Re: Proposed QuarryWEST Masterplan
Response to Issues Raised by Roads and Maritime Services (RMS)

I have reviewed the issues raised by the RMS concerning the QuarryWEST Masterplan proposal. This letter sets out a response to those issues raised by the RMS.

QUARRY WEST ESTATE
RECONCILIATION RD, PEMULWUY
CONCEPT INTERSECTION LAYOUT
RECONCILIATION RD & BELLEVUE CCT

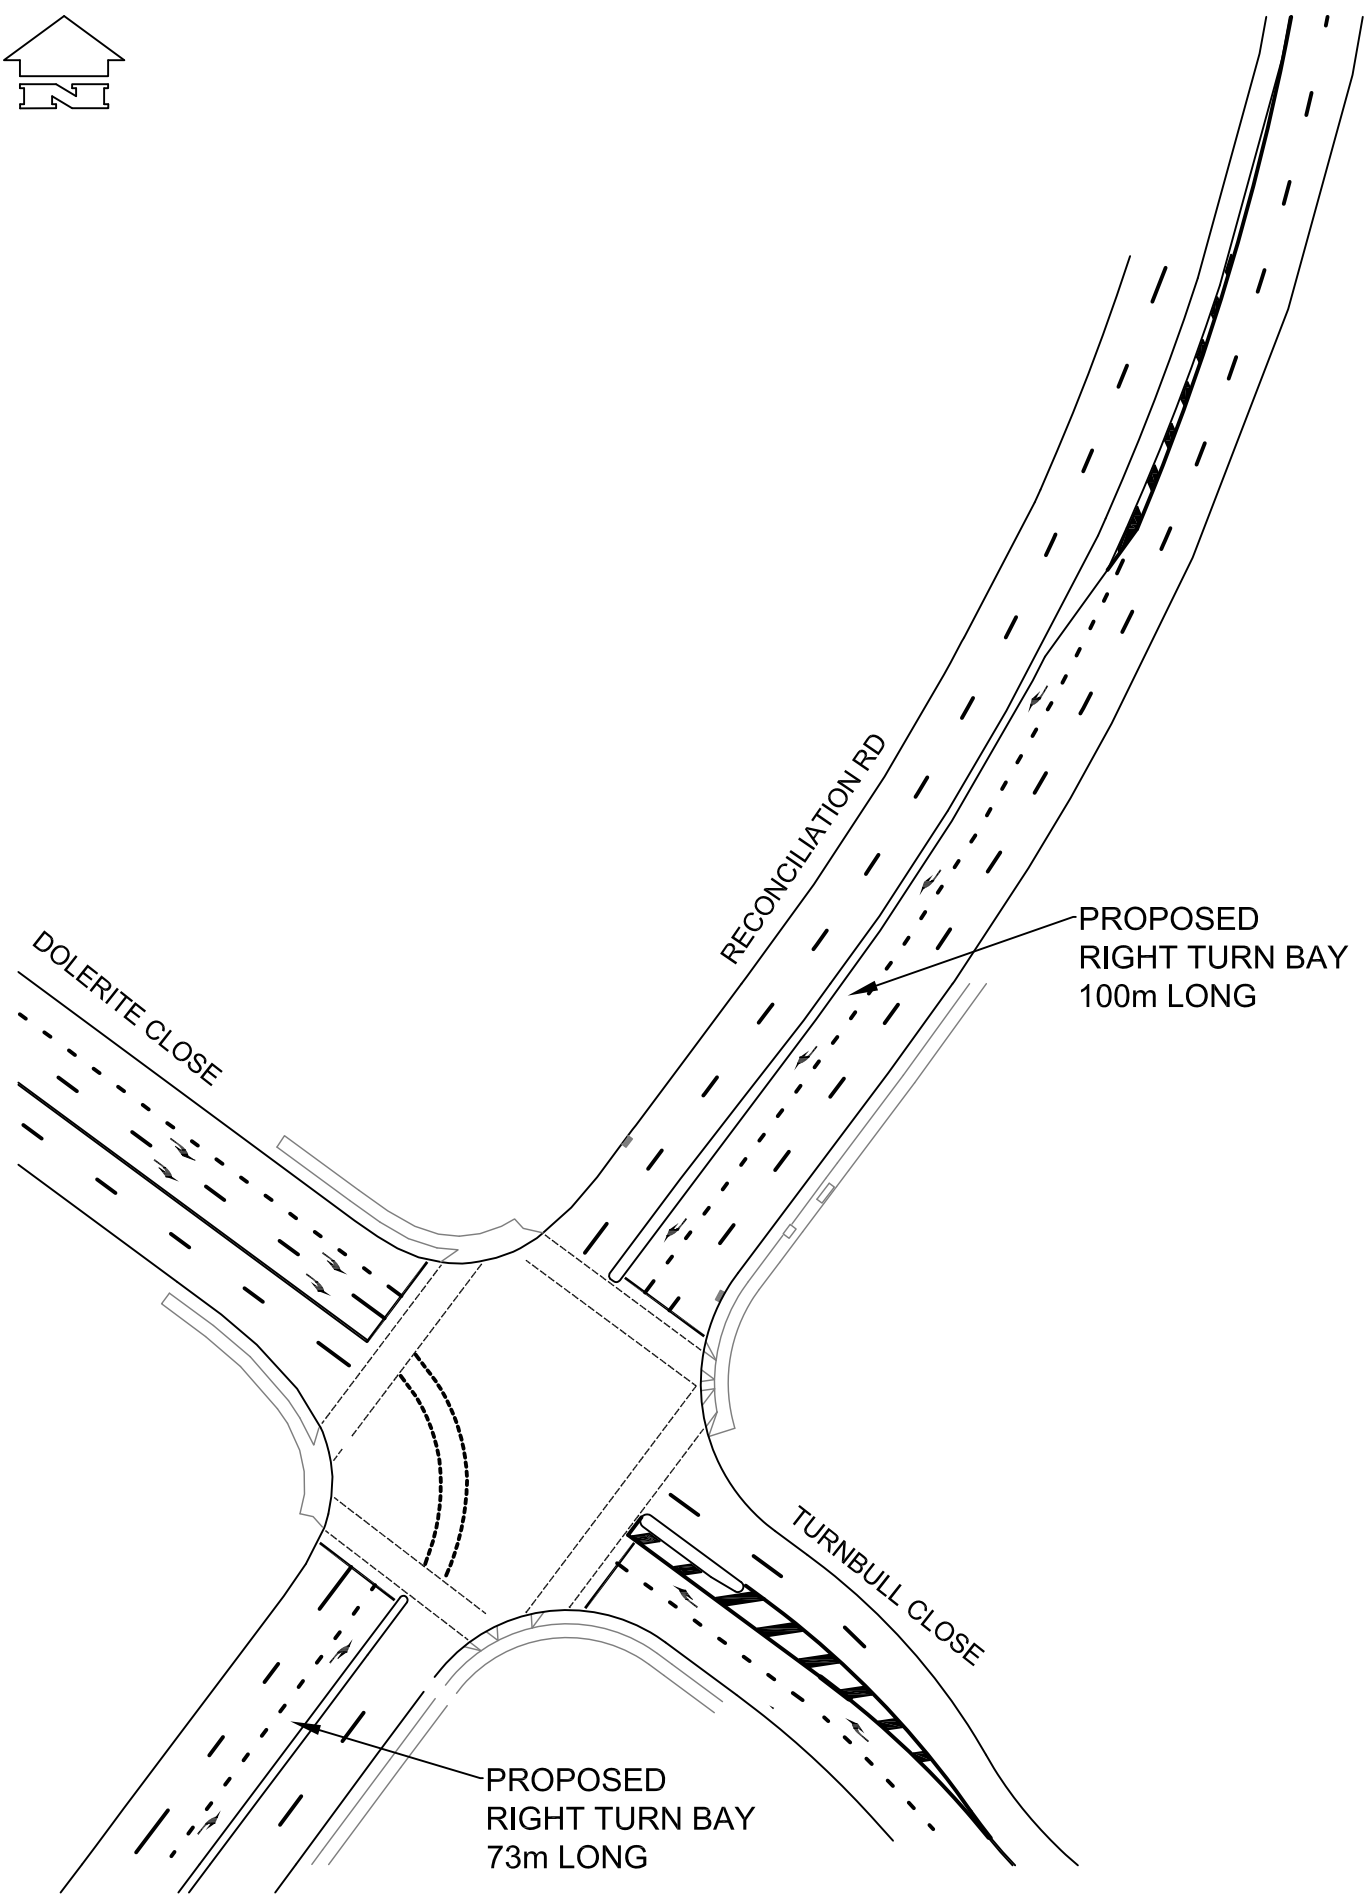
The applicant has proposed a 100m right turn bay into Dolerite Close as part of this application and an 80m right turn bay into Bellevue Crescent and a 110m right turn bay into Basalt Road. Roads and Maritime requires an electronic copy of the SIDRA modelling undertaken for all three intersections to assess the adequacy of the right turn bay length.

SIDRA traffic modelling files are enclosed for the 3 intersections. This modelling indicates that right turn bay lengths for the existing and proposed right turn bays and are of sufficient length, to prevent any of the right turn bays from queuing out.

FIGURE 6
QUARRY WEST ESTATE
RECONCILIATION RD, PEMULWUY
CONCEPT INTERSECTION LAYOUT
RECONCILIATION RD, DOLERITE CL & TURNBULL CL
JOB NO.14136

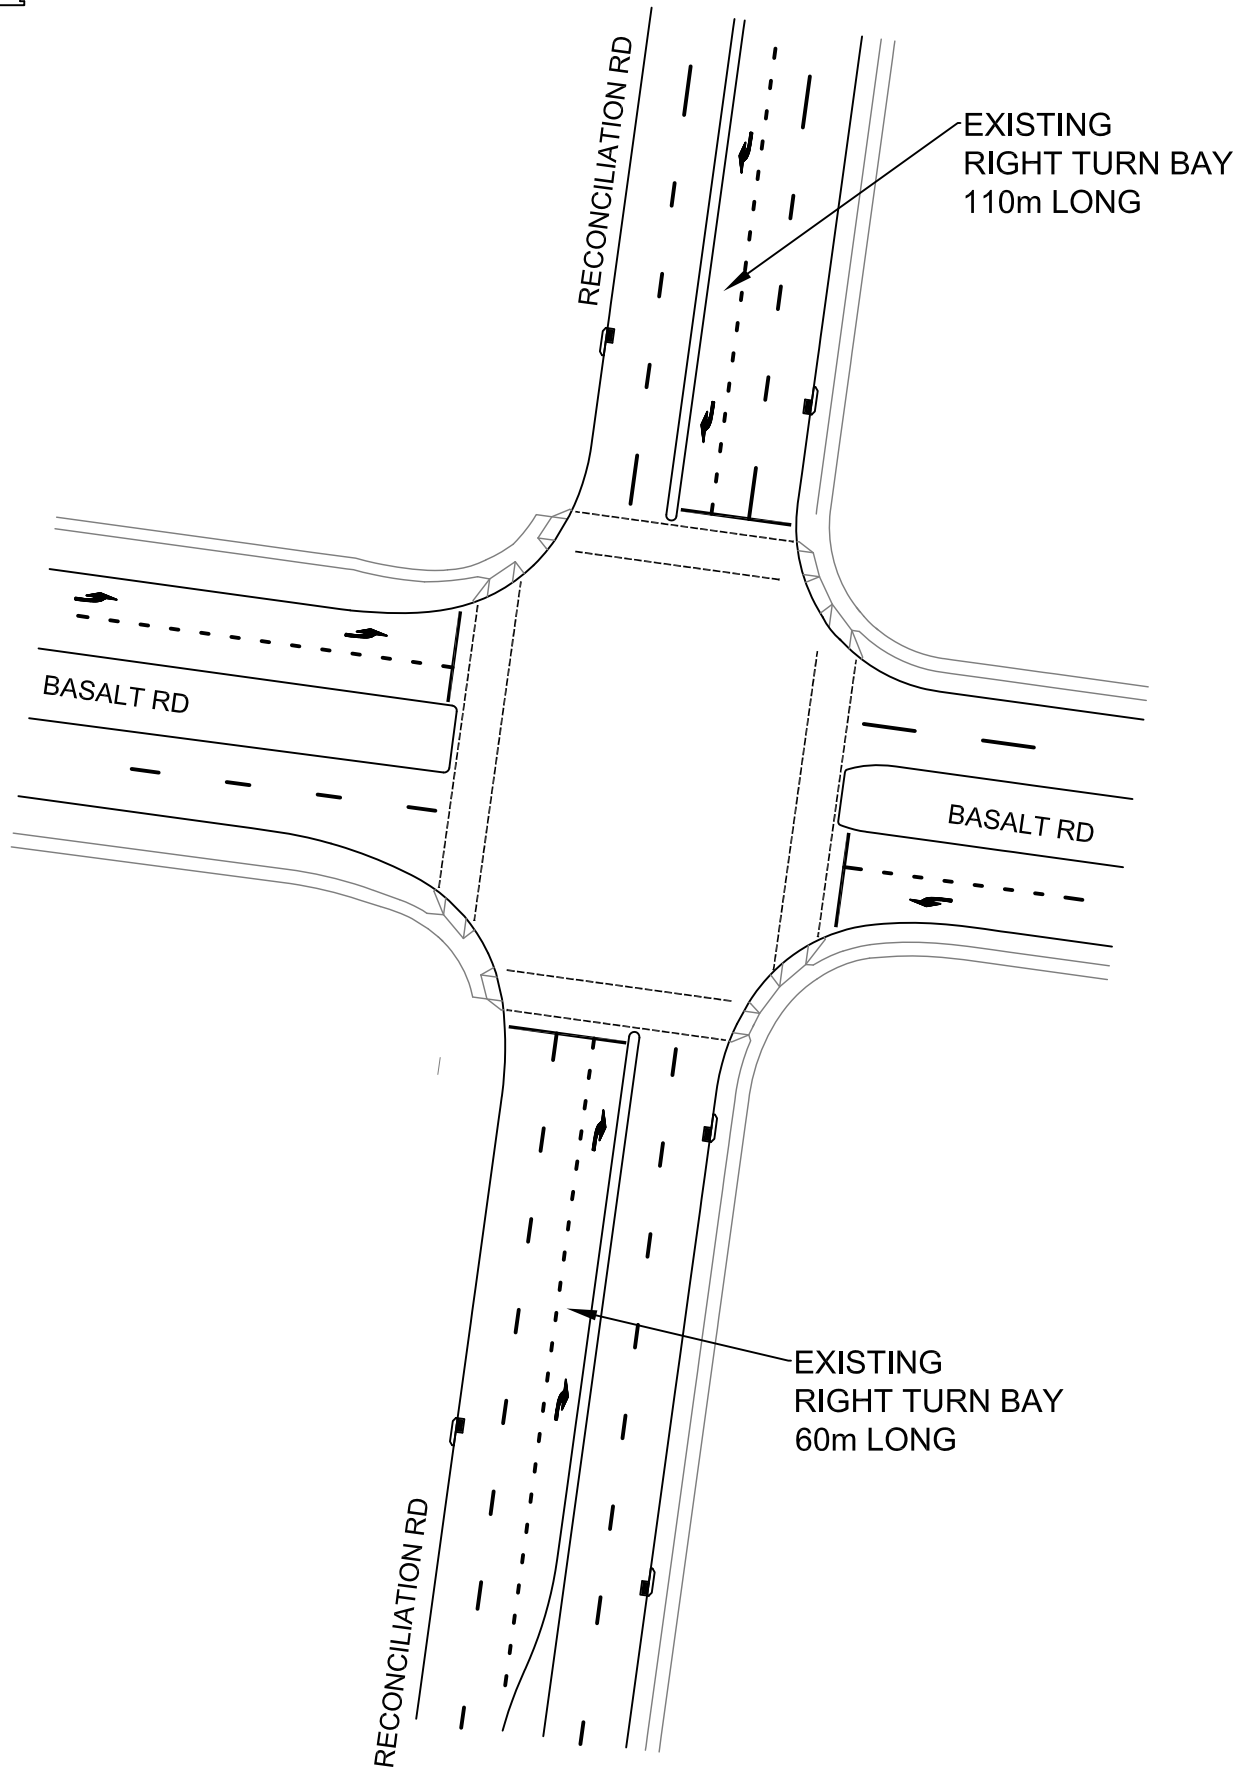
It is noted that Roads and Maritime did not support a right turn bay from Reconciliation Road into Dolerite Close previously. The applicant shall provide justification of reasoning for the right turn bay at this intersection. The applicant shall demonstrate the traffic signal warrants for this intersection have been met.

Prospect Highway (Reconciliation Road) at the Dolerite Close and at the Bellevue Circuit intersection. At both intersections new right turn bays are proposed and the traffic signal phasing would include diamond turns for the right turn movements in Prospect Highway. (Reconciliation Road). Signalised diamond turn arrangements where opposing right turn movements turn at the same time are very efficient in terms of maximising intersection capacity.

The proposed right turn bay in Prospect Highway at Dolerite Close is part of these enhancements and allows the right turn to be safely accommodated at the intersection. The right turn movement into Dolerite Close is estimated to be up to 133 vehicles per hour (vph). As noted above, the intersection will have a satisfactory level of service.

The traffic signal warrant is therefore met by the expected traffic volumes using the intersection with Reconciliation Road at the intersection carrying 1527vph to 1600vph (ie. greater than 600vph in each direction) and Dolerite Close carrying between 201vph to 422vph in one direction for a minimum of 4 hours per day. More importantly given the relatively high proportion of trucks using the intersection and the intersection geometry with multiple lanes in Prospect Highway, it is considered that it would be unsafe to not provide traffic signals and allow the intersection to operate under sign control.
